DOC18/900871-20 ; EF14/502

**Bobs Farm Sand Mine Project (SSD 6395)  
Request for Comments and Recommended Conditions of Approval**

## Attachment A: Further information required

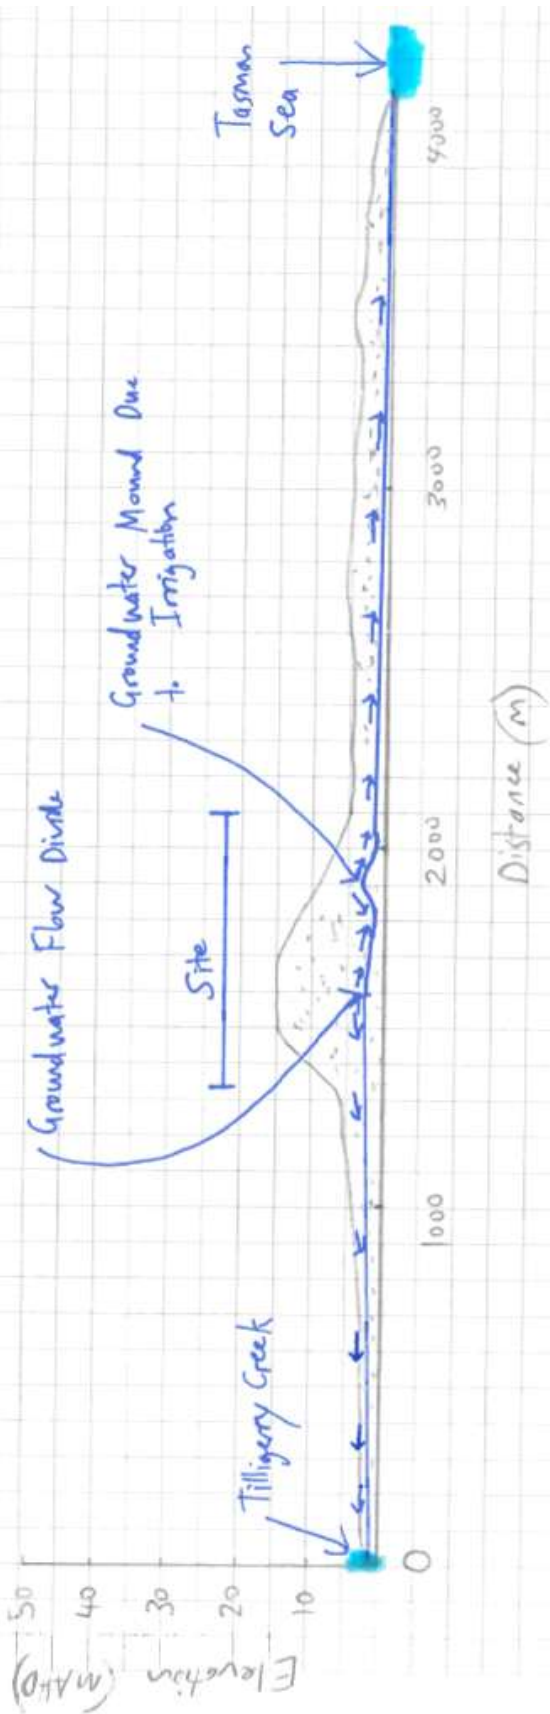
- A revised hydrogeological cross section (figure 7.12 of the EIS) to allow for easy conceptual analysis of site location. A more concise and clearer cross section would help in determining groundwater behaviour across the project site.

- Revised groundwater flow assessment. Groundwater characteristics of the project site were determined from the sampling results mentioned above. A crude schematic diagram was provided to determine the direction of flow across the site, which reveals a hydraulic gradient with groundwater flows to the north of the proposed quarry. It was determined that the hydraulic gradient, using the standing water levels from all five on-site monitoring bores, was in fact westerly to south westerly (see above below). Further groundwater sampling events and updates from the on-site loggers would be beneficial in determining the groundwater characteristics of the project site.
